Consultation Response from KC Waste Strategy (Refuse & Cleansing)		
PA no. & address: 2021/90304 off, Low Westwood Lane, Wellhouse, Golcar, Huddersfield, HD7 4EW		
Proposal: Erection of 7 dwellings, car parking and associated works (within a Conservation Area)		
Date Responded: 05/03/2021	Responding Officer: Carol Oakden	Responding Ref: WPS-21-003

Ground Floor P
1 : 100

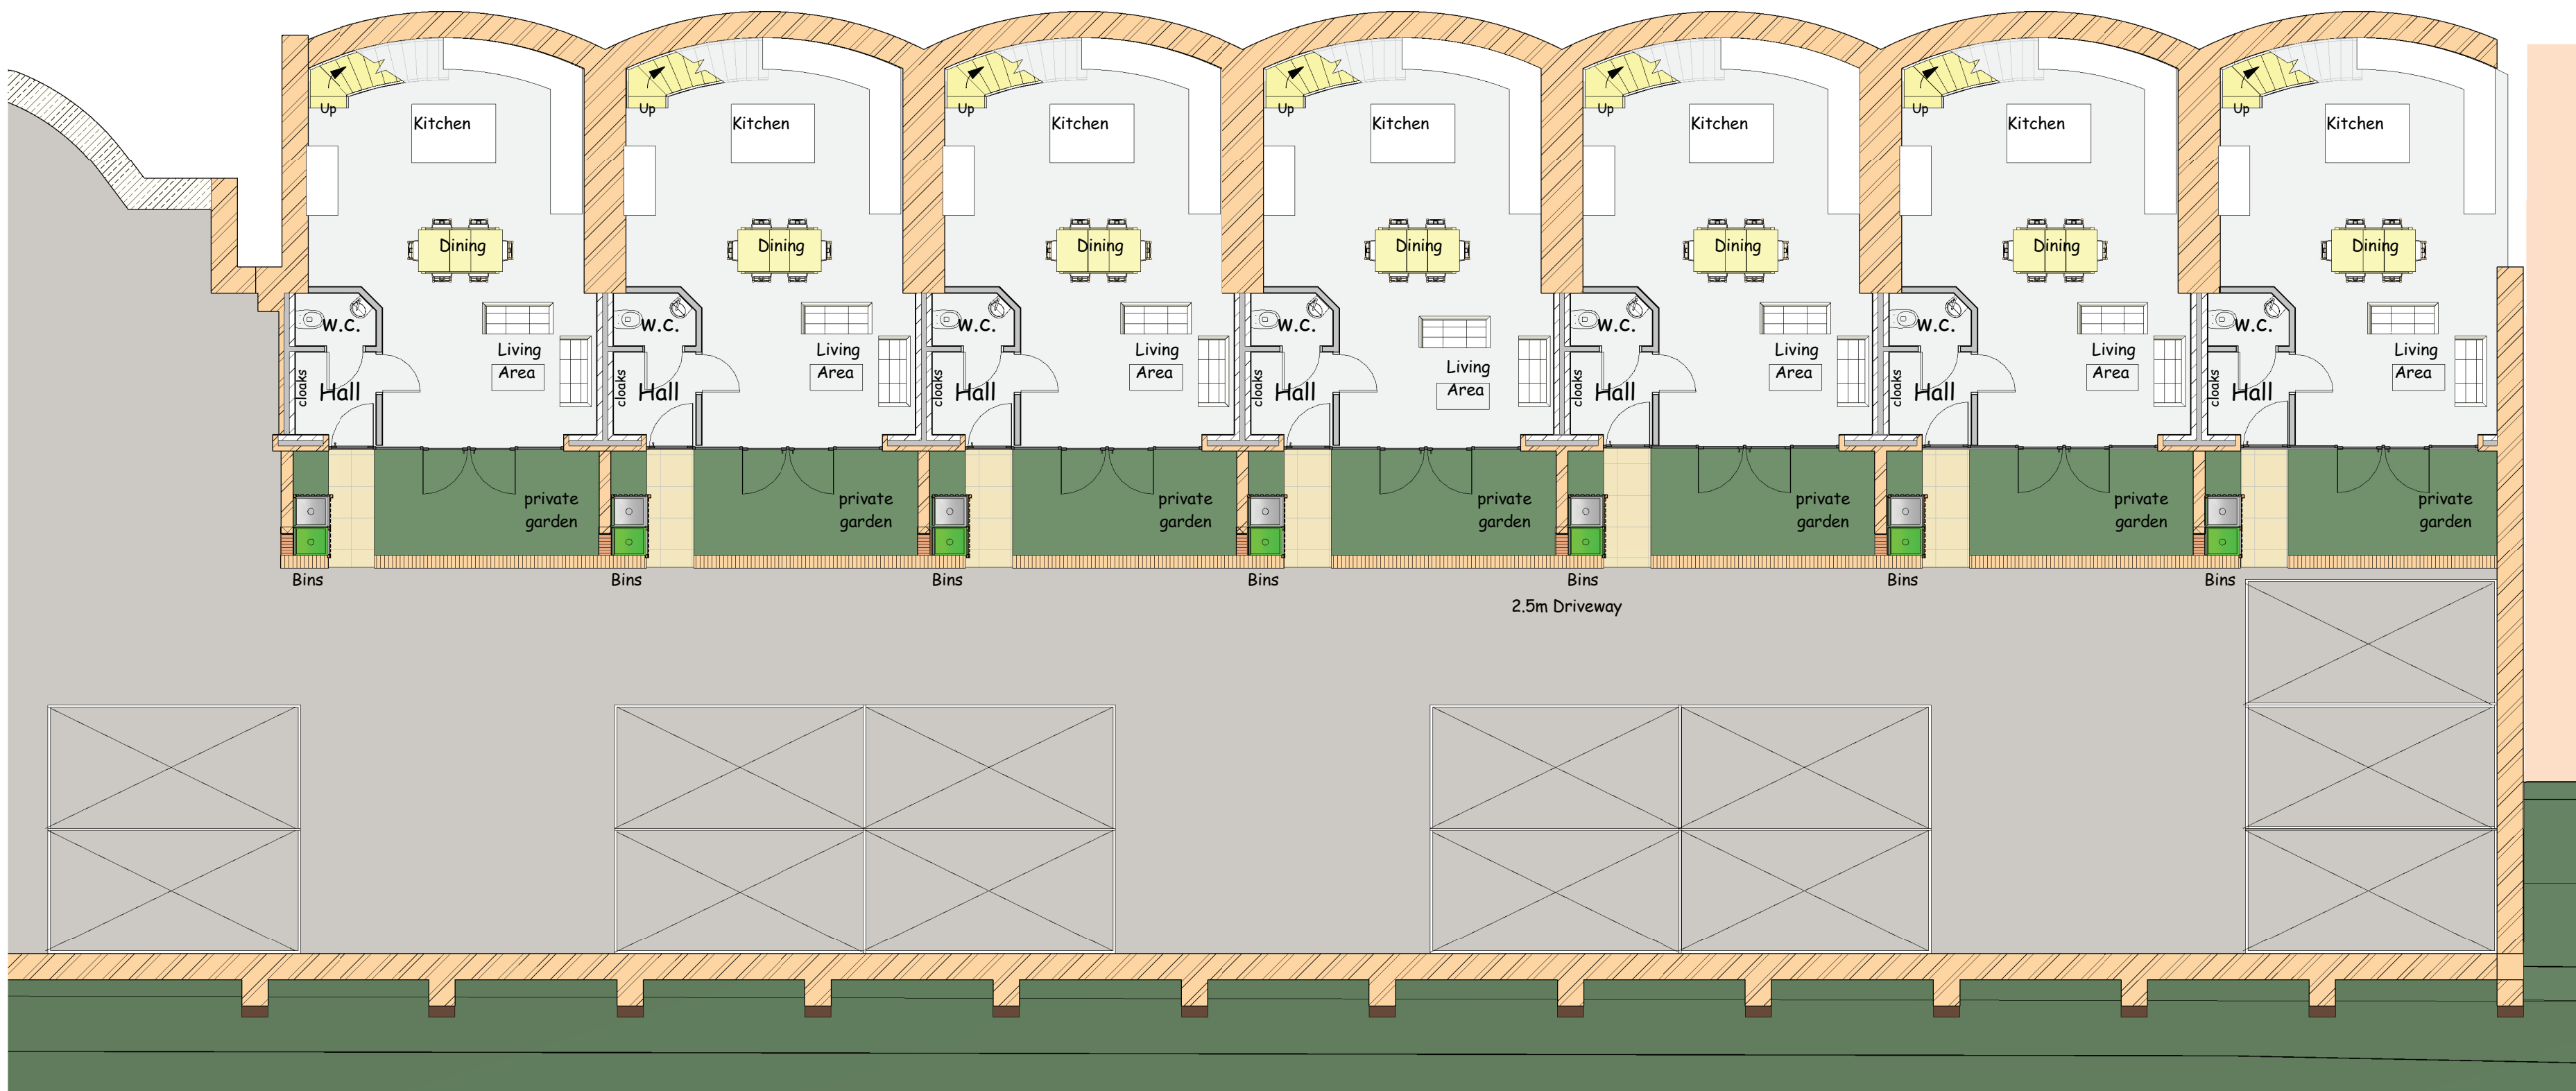
- Bin storage space is identified for each plot in private garden space. However, this only shows 2 x 240ltr bins per property and space is required for 3 of these bins. This will enable households to take advantage of increased recycling services such as garden waste, glass or additional green recycling bins in the future, in line with the Authority's strategic direction towards increasing the district recycling rate.

- The narrow road/parking area to the front of the properties will likely not be suitable for bins to be collected from. Therefore, a communal presentation space must be identified for bins to be brought to on collection day. This must be as close as possible to the nearest adopted highway. The distance from the proposed dwellings to Low Westwood Lane itself is in excess of 70m – considerably more than the suggested maximum of 25m that residents should be expected to pull bins. However, it may be necessary for residents to accept a longer drag distance in order to receive a safe and efficient waste collection service from Low Westwood Lane (subject to the RCV comments below).

- Suitable site access and manoeuvrability space for a Refuse Collection Vehicle is vital to the Council's ability to discharge its obligation to collect waste from domestic properties. This obligation will exist in perpetuity on any residential development and as such should be a critical consideration in the layout of the site if approval is granted. It is not clear from the submitted plans if an RCV will

be required to enter the site given the gated access is set to remain. It must be demonstrated that an RCV can safely serve the site without causing obstruction or endangering waste operatives, particularly given the situation of the site at the bend in the road. If an RCV is expected to enter the site, will there be provision to turn around and exit the site in a forward gear? Further information should be required on this for consideration by Highways colleagues from a technical/safety perspective.
